# Kiltiernan SHD

## Lands at Wayside, Kiltiernan

Quality Audit

Liscove Ltd.

JUNCTION No. 12
23m VISIBILITY SPLAY (Y)
2m SET BACK (X)

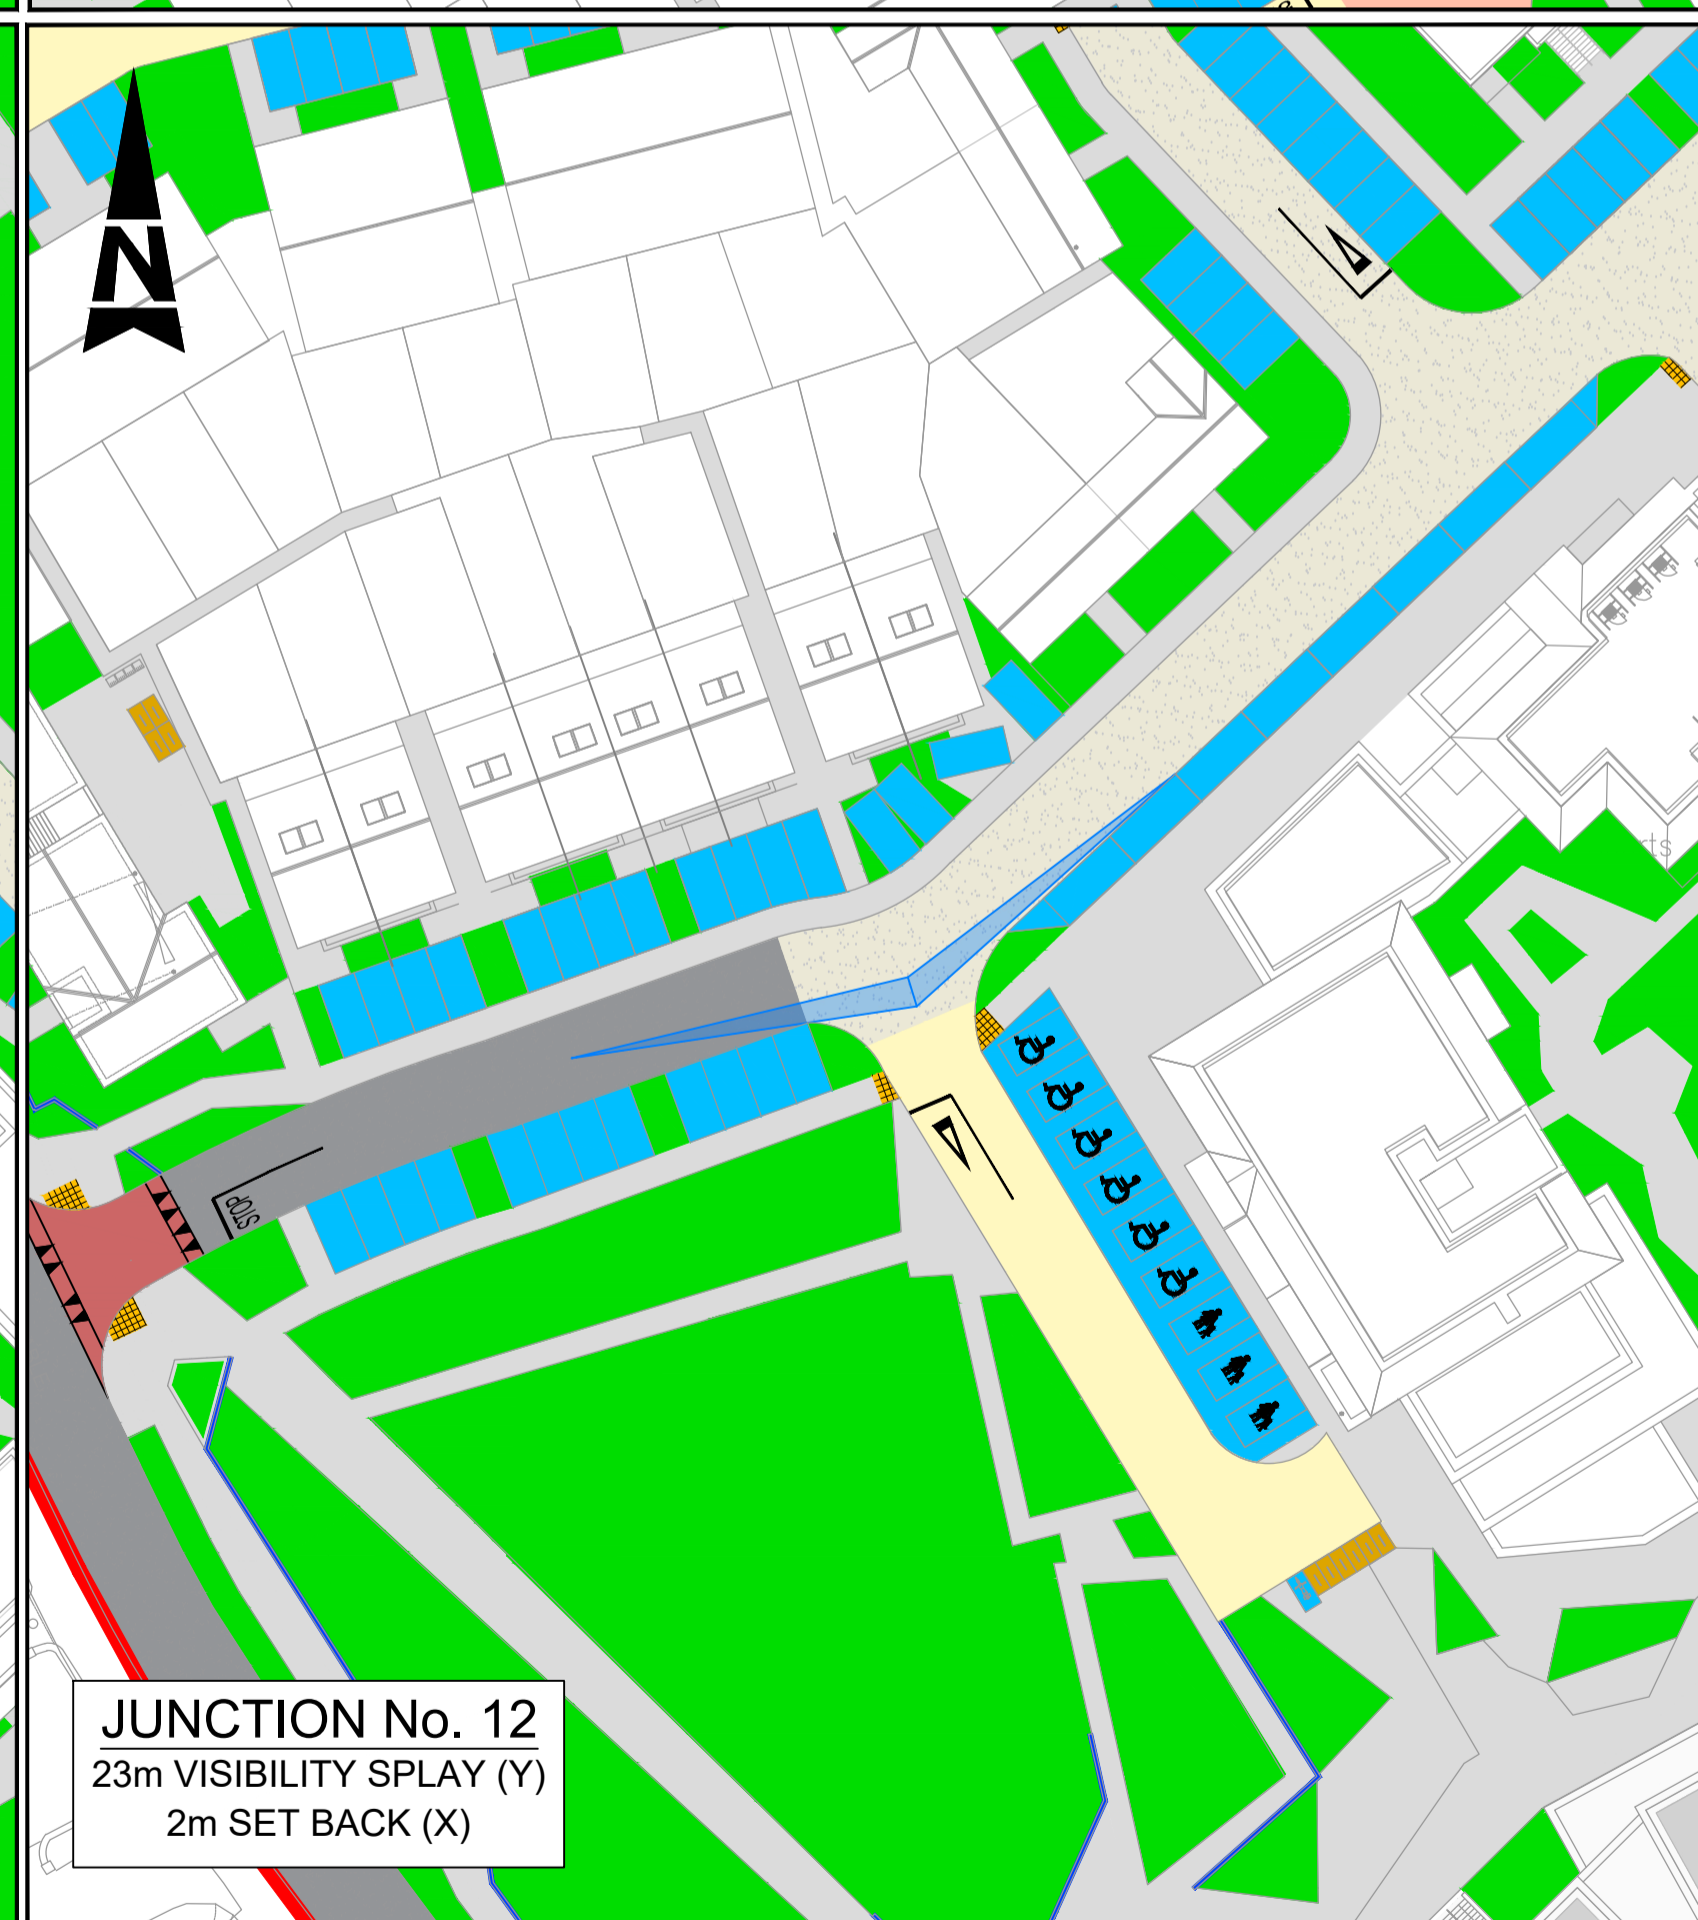
The angle of footpaths and tactile paving is such that users may be incorrectly directed across the junction and fail to reach the opposing footpath. This may lead to an increased risk of conflict with vehicles moving through the junction.

A similar concern relates to Junction 12.

The layouts should be amended to have the crossing lining up directly on both sides of the junction.

Orders and ban on “wheel stoppers” will be implemented. Parking for these units on Enniskerry Road is provided to the rear. This includes provision for visitor car parking and servicing.	
3.5	Y	Y

The scheme proposes 3 junctions on the west along the Enniskerry Road. Crossing provision for pedestrians, cyclists and less abled user have not been detailed in the scheme proposals. The existing Enniskerry Road was observed to have relatively frequent traffic travelling at moderate speed. The nearest crossings are located at the village of Kiltarnan at Farmer Brown's public house and the Circle K further south which are approximately 500m apart. It is unlikely that people will utilise these to cross the road and attempt to cross the road closer to Junctions 2, 3 and 4. Where adequate provision is not provided, conflict may arise.

The Designer should assess the scheme proposals in the context of likely desire lines across Enniskerry Road and propose measures that would cater for desire lines and demand. The provision of a crossing(s) would also likely contribute to calming traffic speed along the road in addition to providing appropriate crossing opportunities for less non-motorised users.
